**WELWYN HATFIELD BOROUGH COUNCIL
EXECUTIVE DIRECTOR - PLANNING, PUBLIC PROTECTION AND GOVERNANCE**

Application No: 6/2022/2251/HOUSE
Location: 21 St Josephs Green Welwyn Garden City AL7 4TT
Proposal: Erection of a single storey rear extension, replacement single storey side/front extension, garden office/study room and pergola, air conditioning/ashp units and solar panels to roofs
Officer: Mrs Kerrie Charles

Recommendation: Refused

Drawing No: 5587-P01 Revision: E

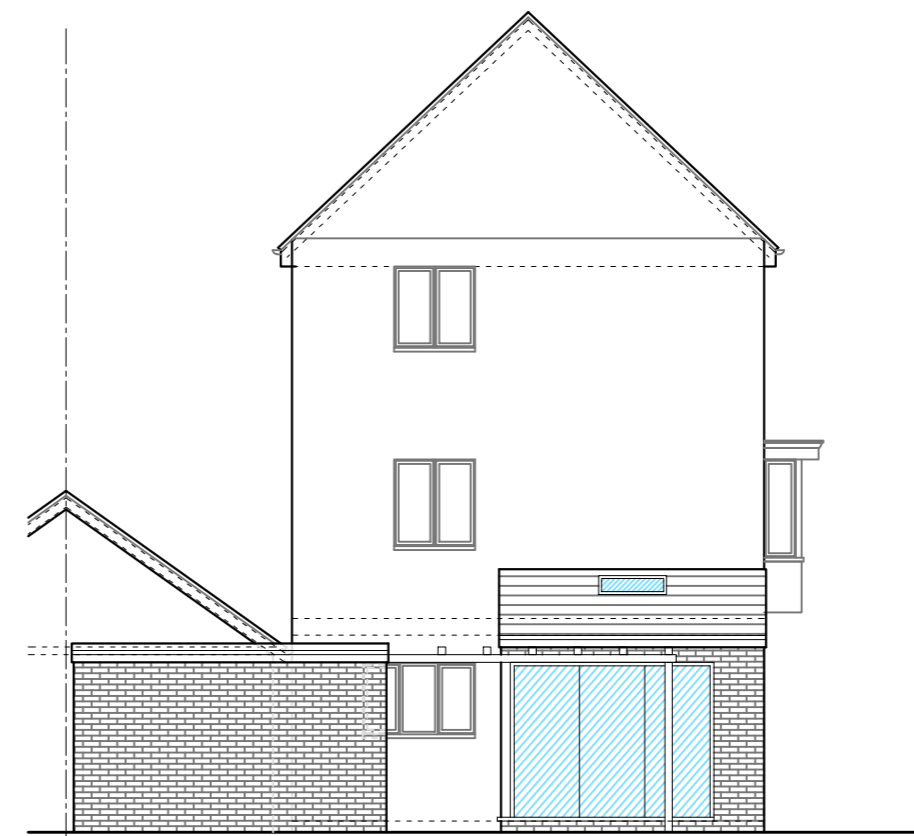
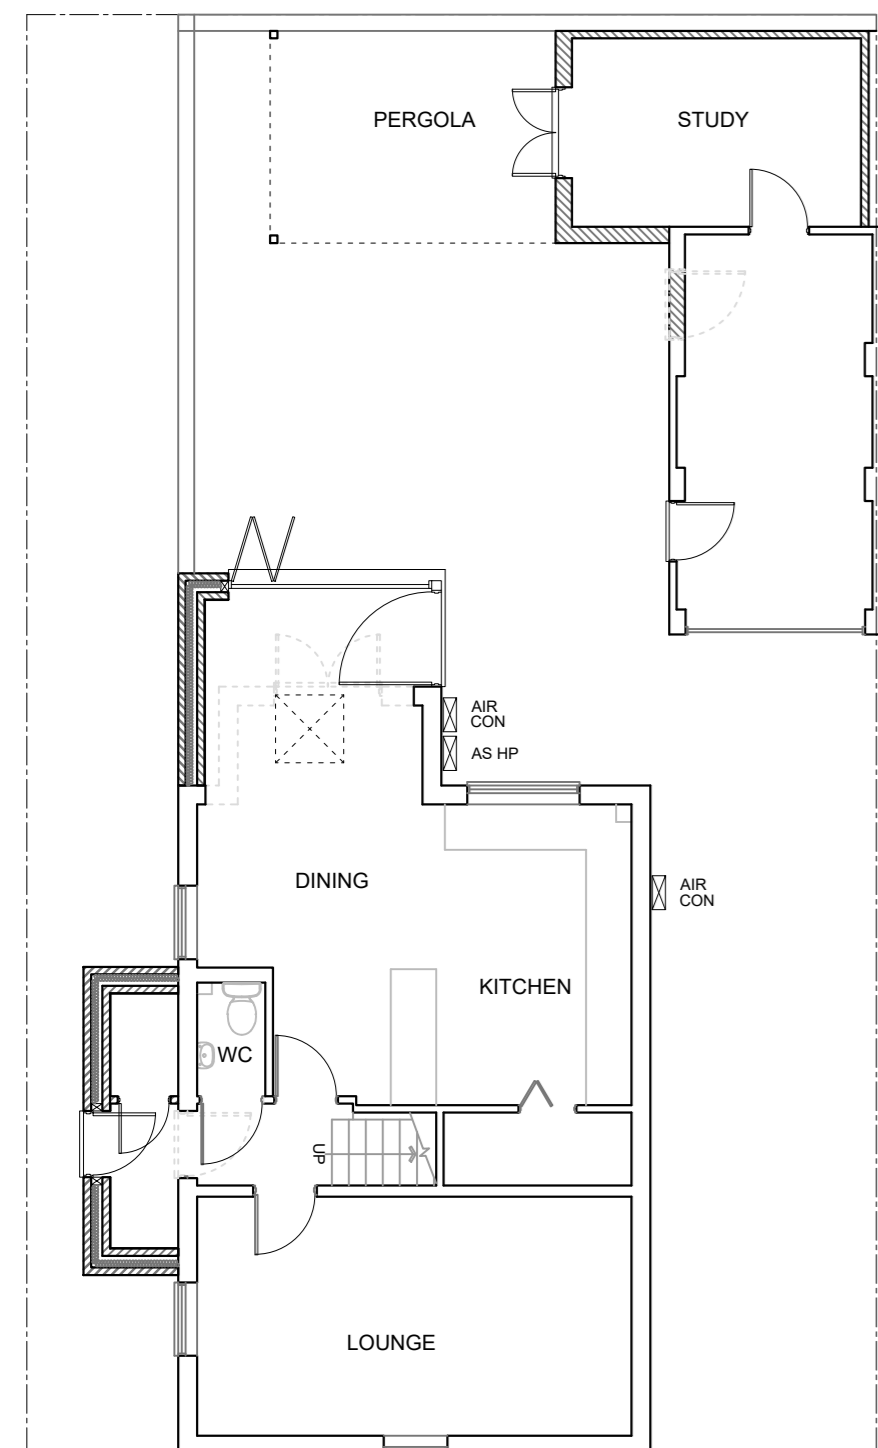
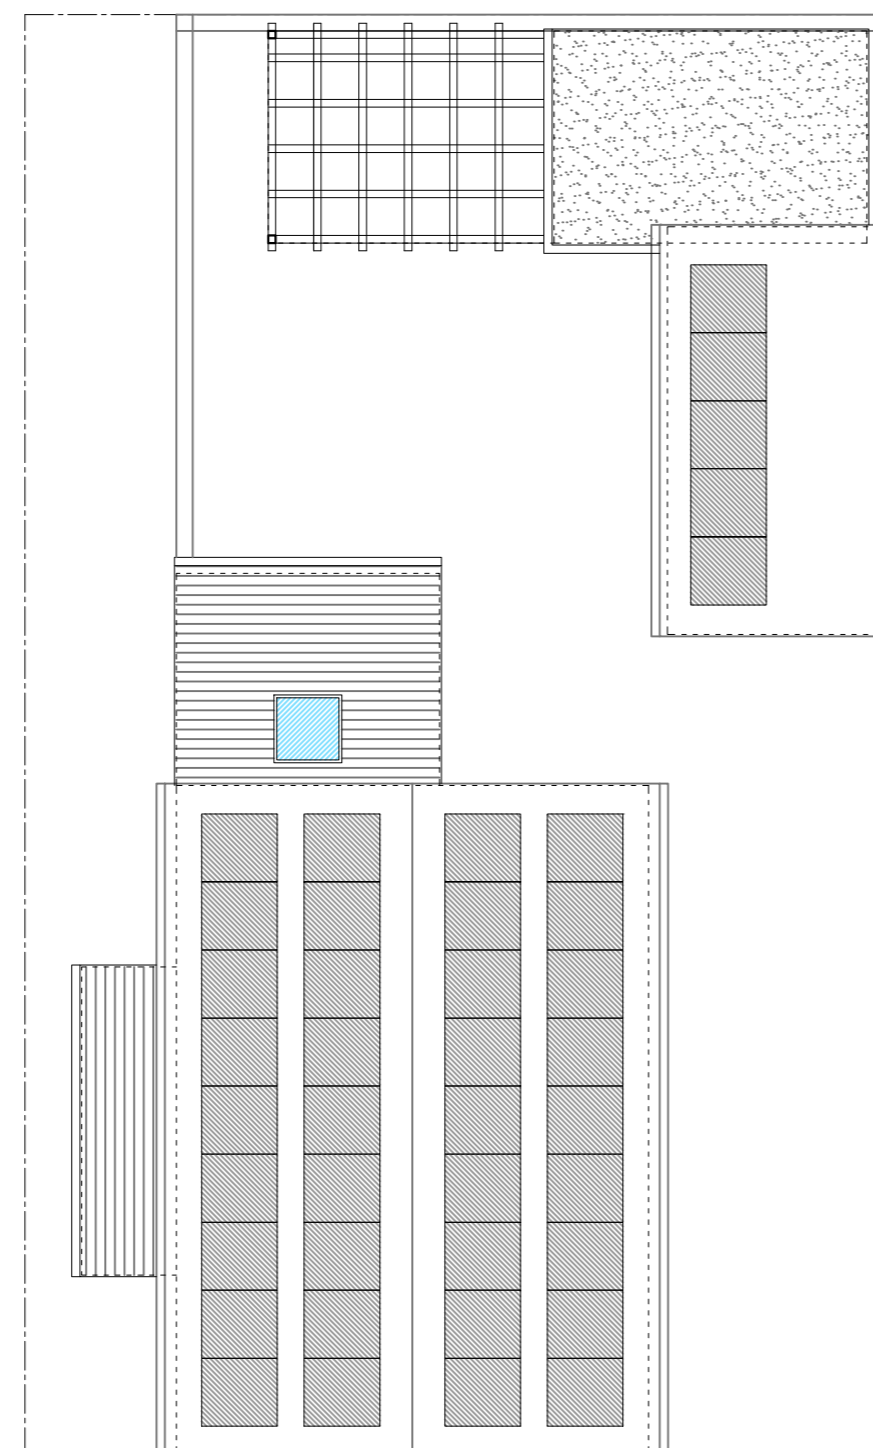
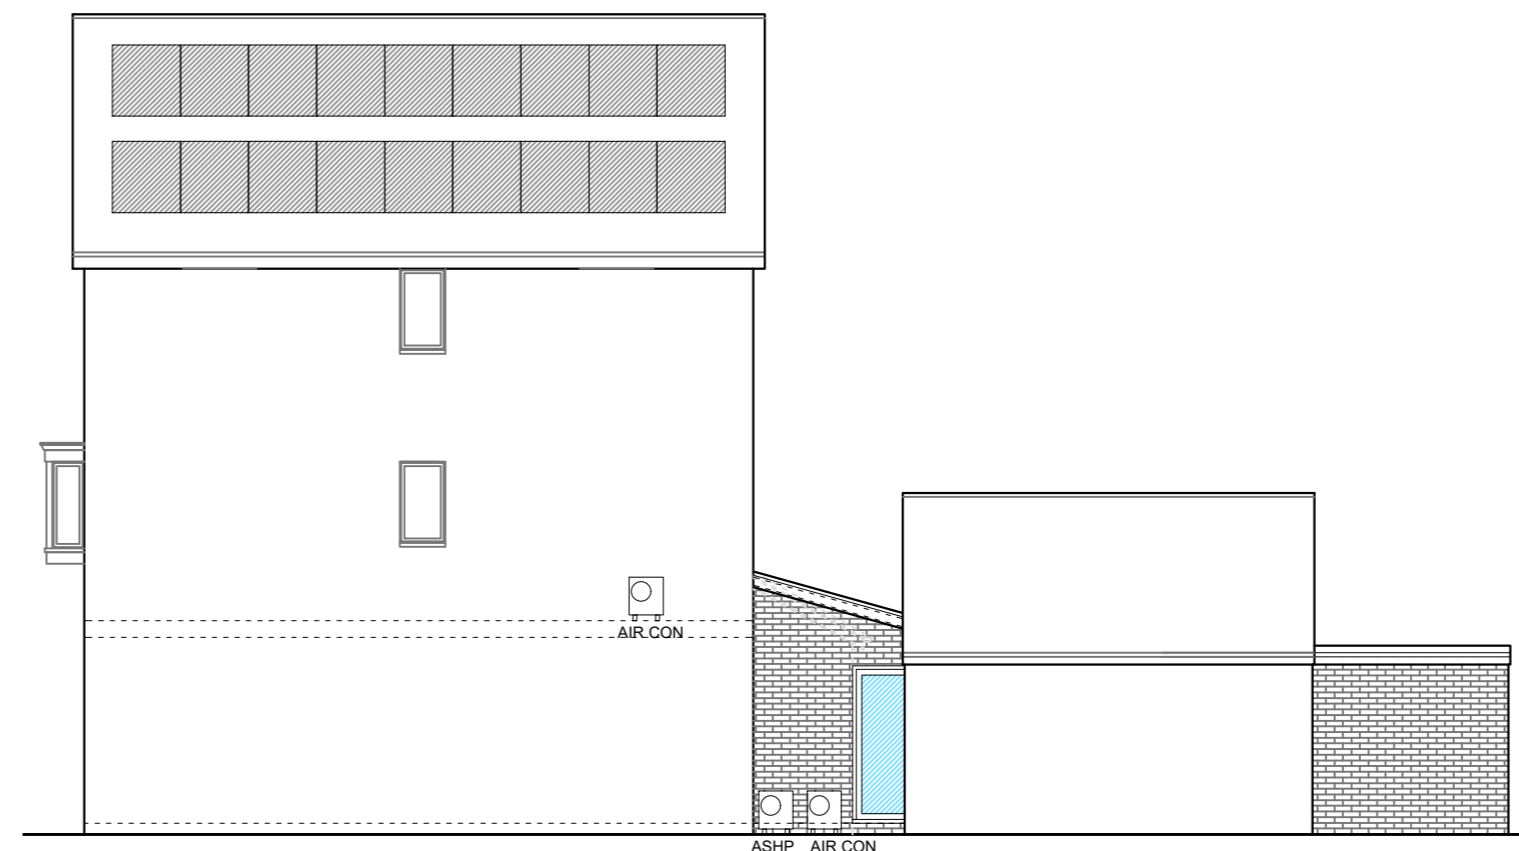
The proposed porch is set back from the highway and projects from the side, the porch would enclose the footpath between the neighbouring property and would adversely affect the character and overall design of the symmetry between both properties

The proposed rear extension to the house and to the garage would not be visible within the streetscene. The pergola would have limited visibility due to the site's orientation. However, taking into consideration the overall accumulation of all the buildings together with the rear extension, the proposed development would be over development and result in the loss of private amenity space

There are no objections in regards to the proposed solar panels and they possibly are considered

The air conditioning units would not have any visibility from outside the application site due to their location and therefore considered acceptable.

Taking account of the above, the proposal would fail to complement and reflect the design and character of the host dwelling. Harm would also be caused to the character of the area given its unsympathetic design and its visibility from neighbouring properties. It is considered that the proposal would represent a poor standard of design in conflict with Policies D1, D2 and GBSP2 of the District Plan, the SDG, Policy SP9 of the Emerging Local Plan and the NPPF.

1. The proposed development, by reason of its scale, siting and appearance, would fail to complement and reflect the design of the host dwelling and the character of the area. Consequently, the proposal would represent a poor standard of design in conflict with Policies D1, D2 and GBSP2 of the Welwyn Hatfield District Plan 2005; Supplementary Design Guidance 2005; Policy SP9 and SADM11 of the Welwyn Hatfield Borough Council Draft Local Plan Proposed Submission August 2016; and the National Planning Policy Framework.
